## EL PASO COUNTY STORMWATER MANAGEMENT PLAN CHECKLIST

SHEET NO.
CE1.1

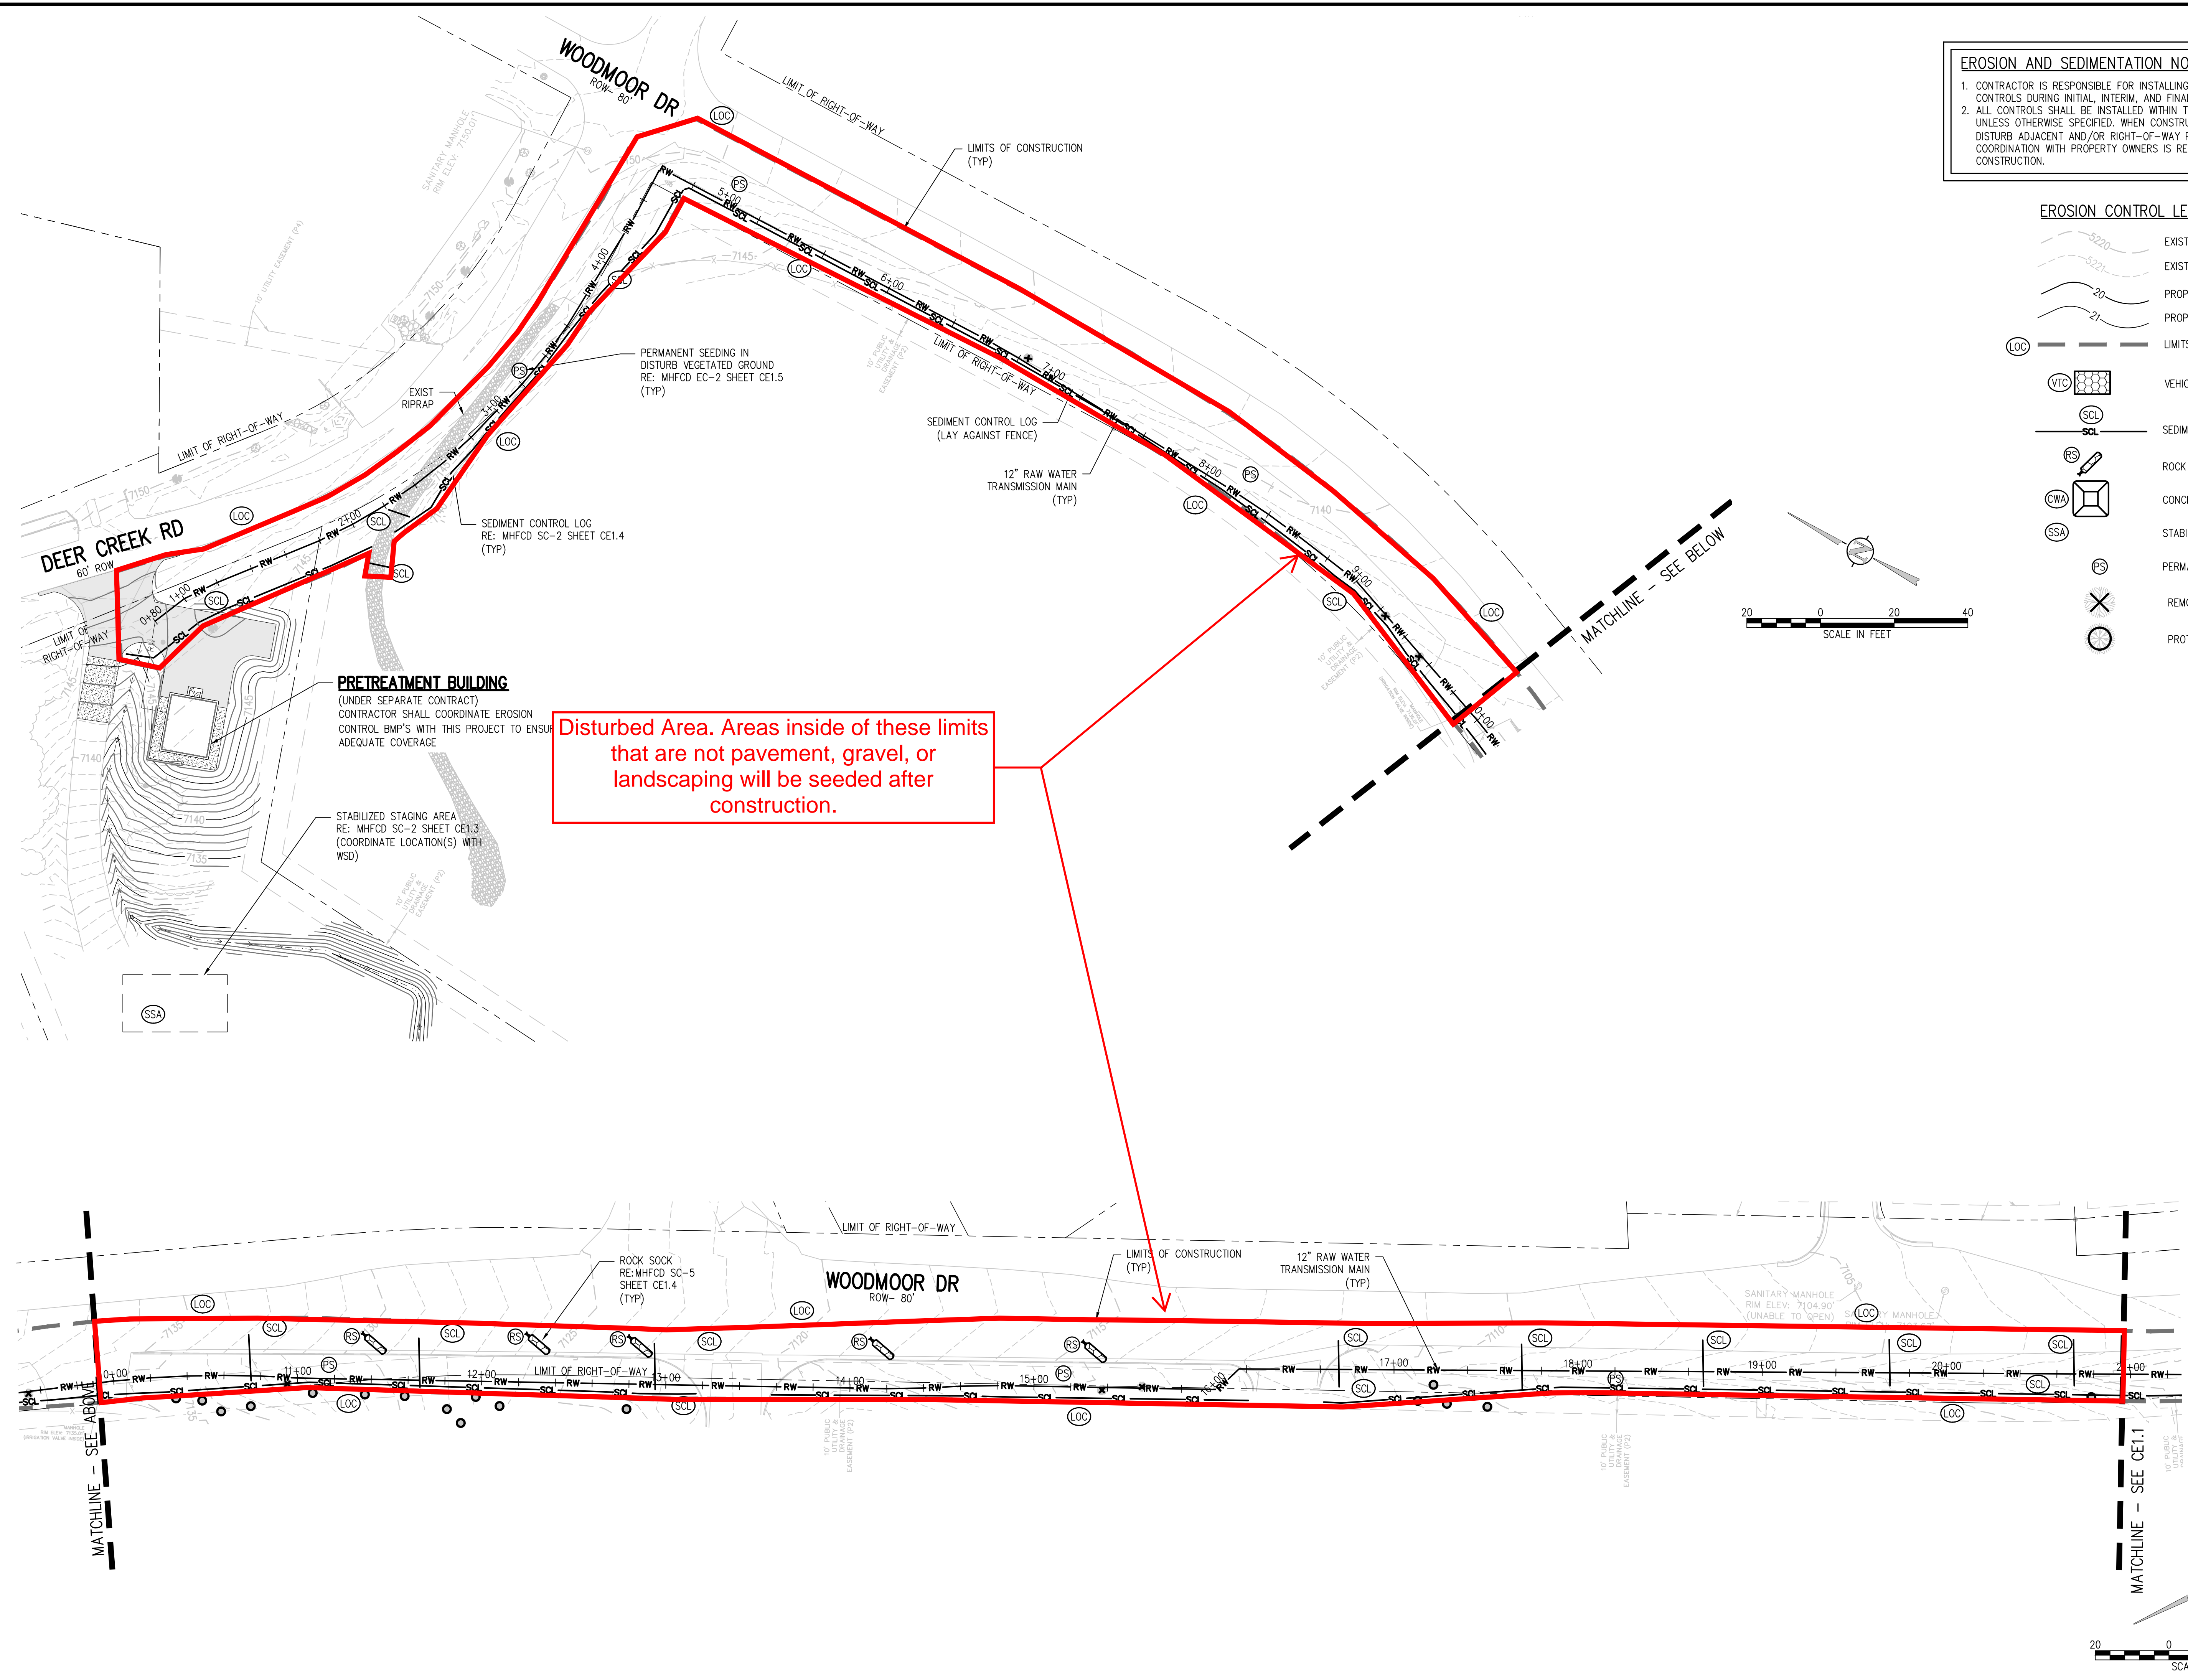
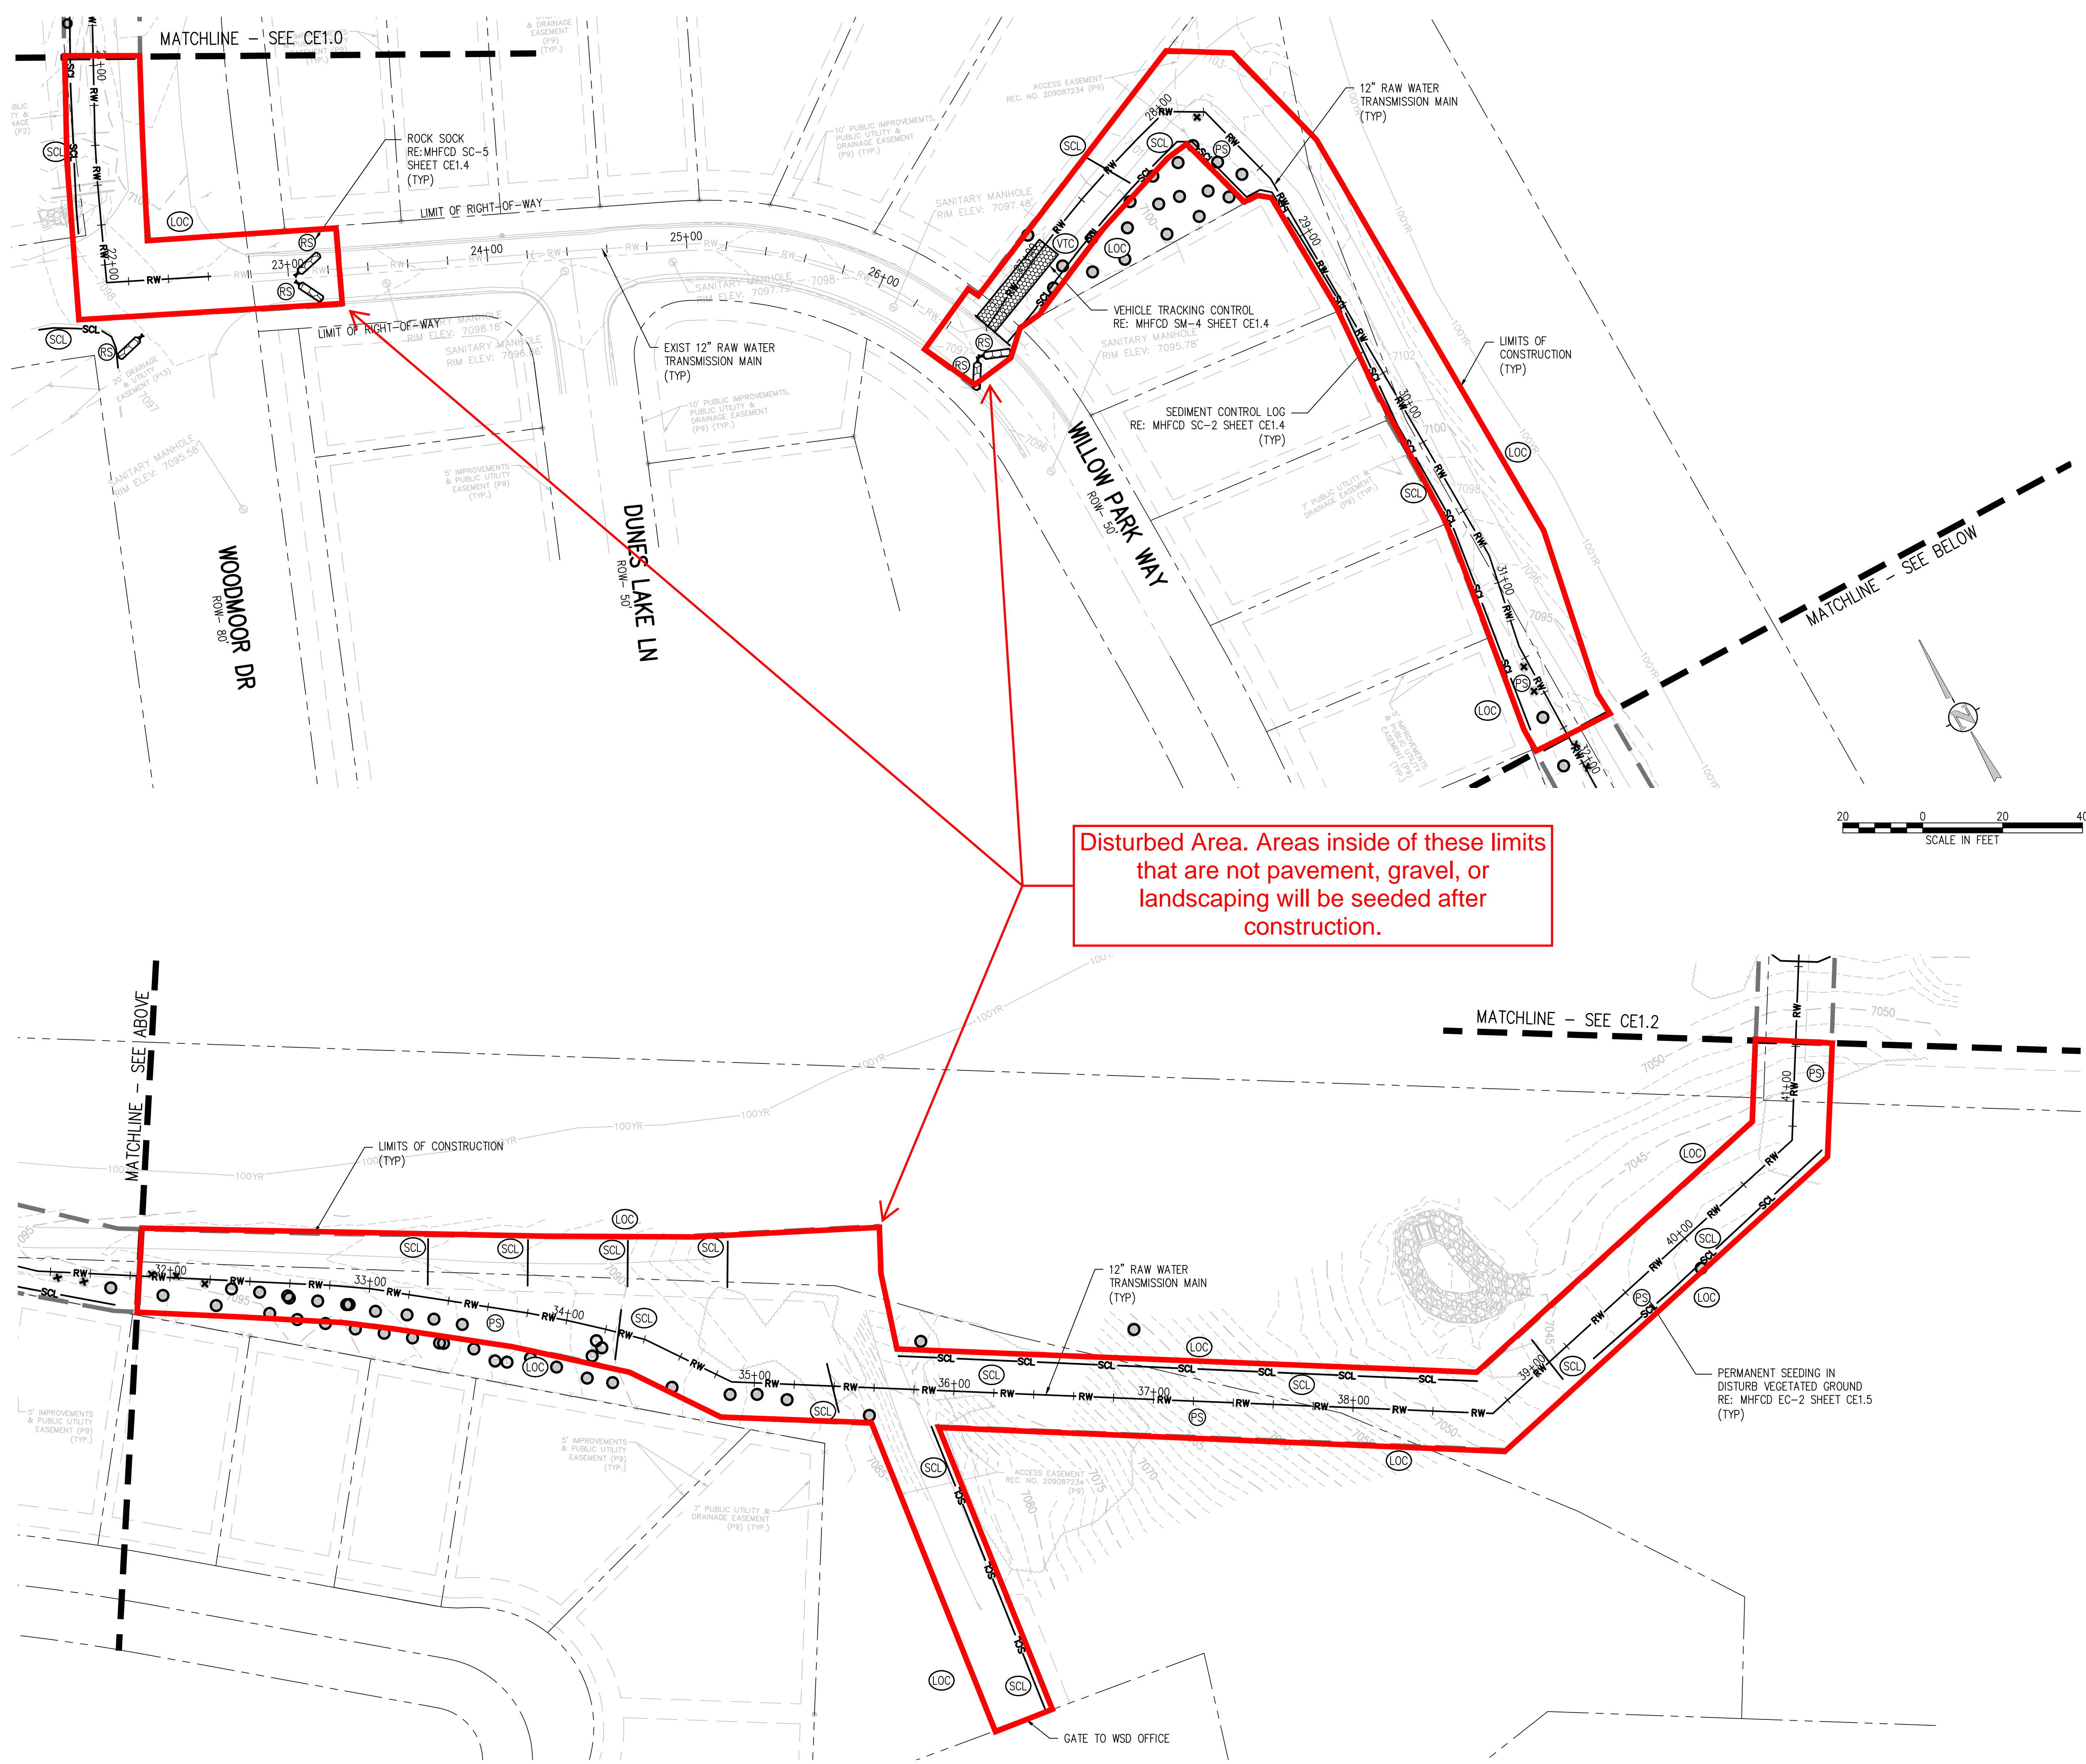
Applicant	EPC
17	SWMP Map to include:		
17a	construction site boundaries		Y
17b	flow arrows to depict stormwater flow directions		N
17c	all areas of disturbance	See comments on plans for these 3 items.	N
17d	areas of cut and fill		N
17e	areas used for storage of building materials, soils (stockpiles) or wastes		Y
17f	location of any dedicated asphalt / concrete batch plants		Y
17g	location of all structural control measures		Y
17h	location of all non-structural control measures		Y
17i	springs, streams, wetlands and other surface waters, including areas that require maintenance of pre-existing vegetation within 50 feet of a receiving water		Y
18	Narrative description of all structural control measures to be used. Modifications to EPC standard control measures must meet or exceed County-approved details		Y
19	Description of all non-structural control measures to be used including seeding, mulching, protection of existing vegetation, site watering, sod placement, etc.		Y

CE1.3

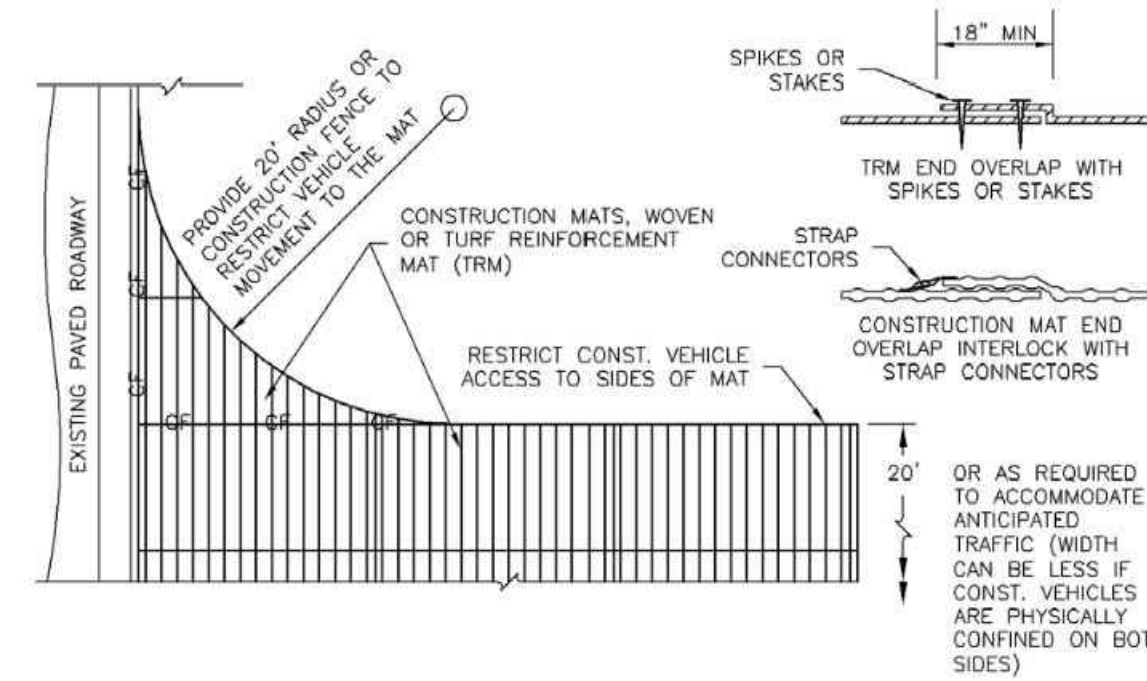
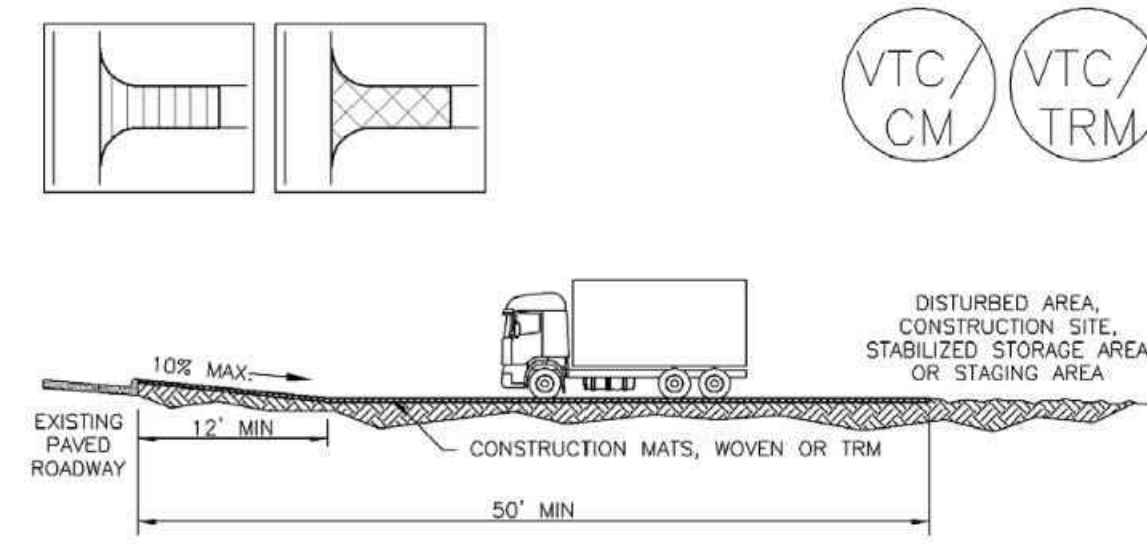
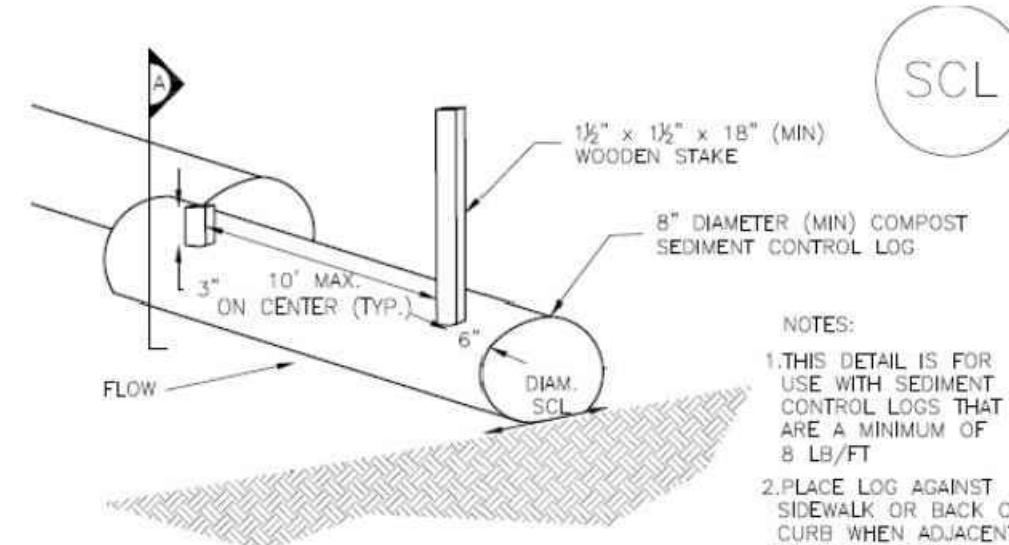
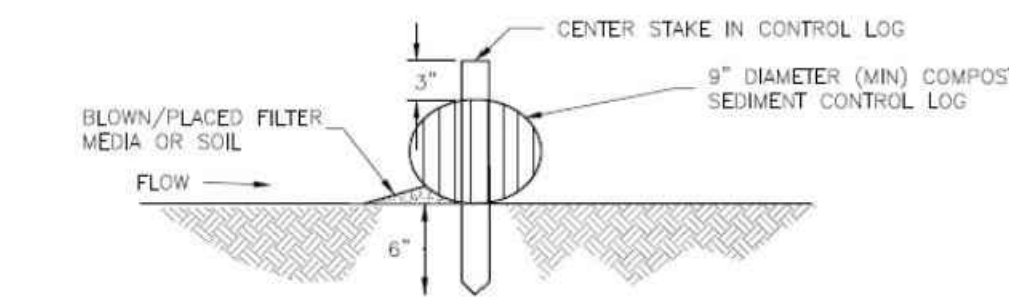
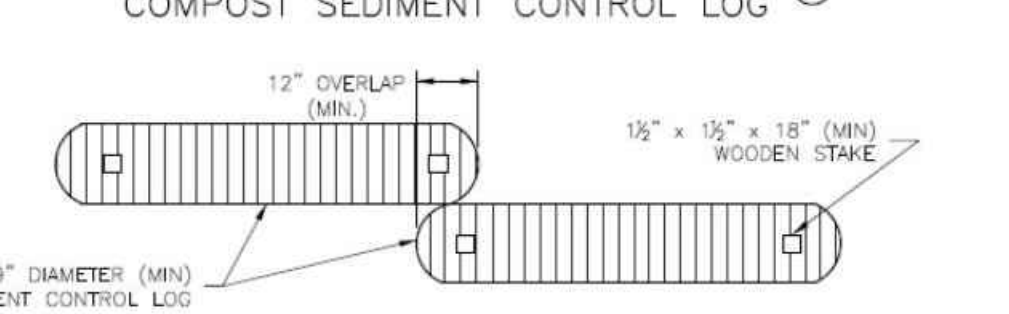
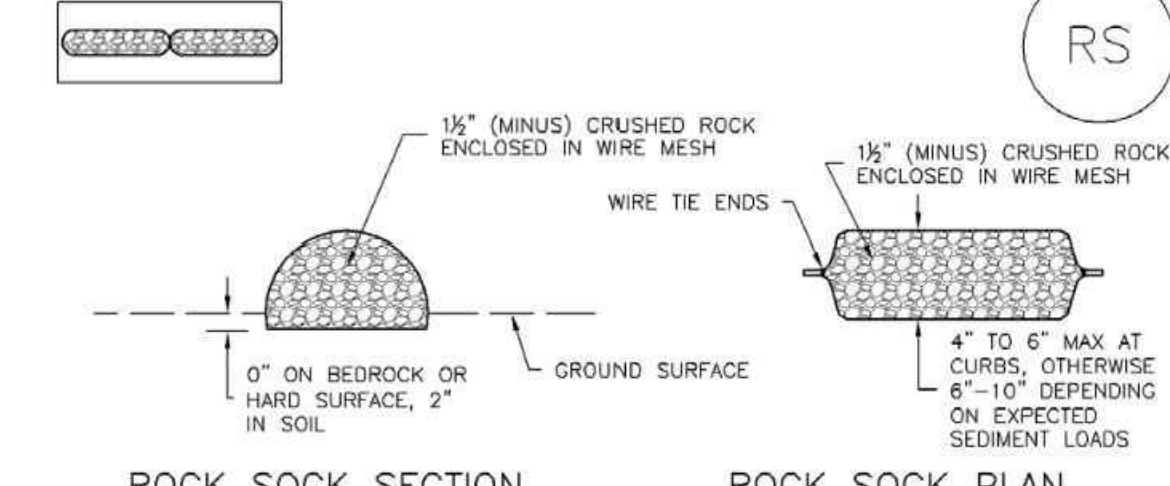
20	Technical drawing details for all control measure installation and maintenance; custom or other jurisdiction's details used must meet or exceed EPC standards	Include in plans as noted on Sheet 5	N
21	Procedure describing how the SWMP is to be revised		N
22	Description of Final Stabilization and Long-term Stormwater Quality (describe nonstructural and structural measures to control SW pollutants after construction operations have been completed, including detention, water quality control measure etc.)		N
23	Specification that final vegetative cover density is to be 70% of pre-disturbed levels		N
24	Outline of permit holder inspection procedures to install, maintain, and effectively operate control measures to manage erosion and sediment		N
25	Record keeping procedures identified to include signature on inspection logs and location of SWMP records on-site		N
26	If this project relies on control measures owned or operated by another entity, a documented agreement must be included in the SWMP that identifies location, installation and design specifications, and maintenance requirements and responsibility of the control measure(s)		N
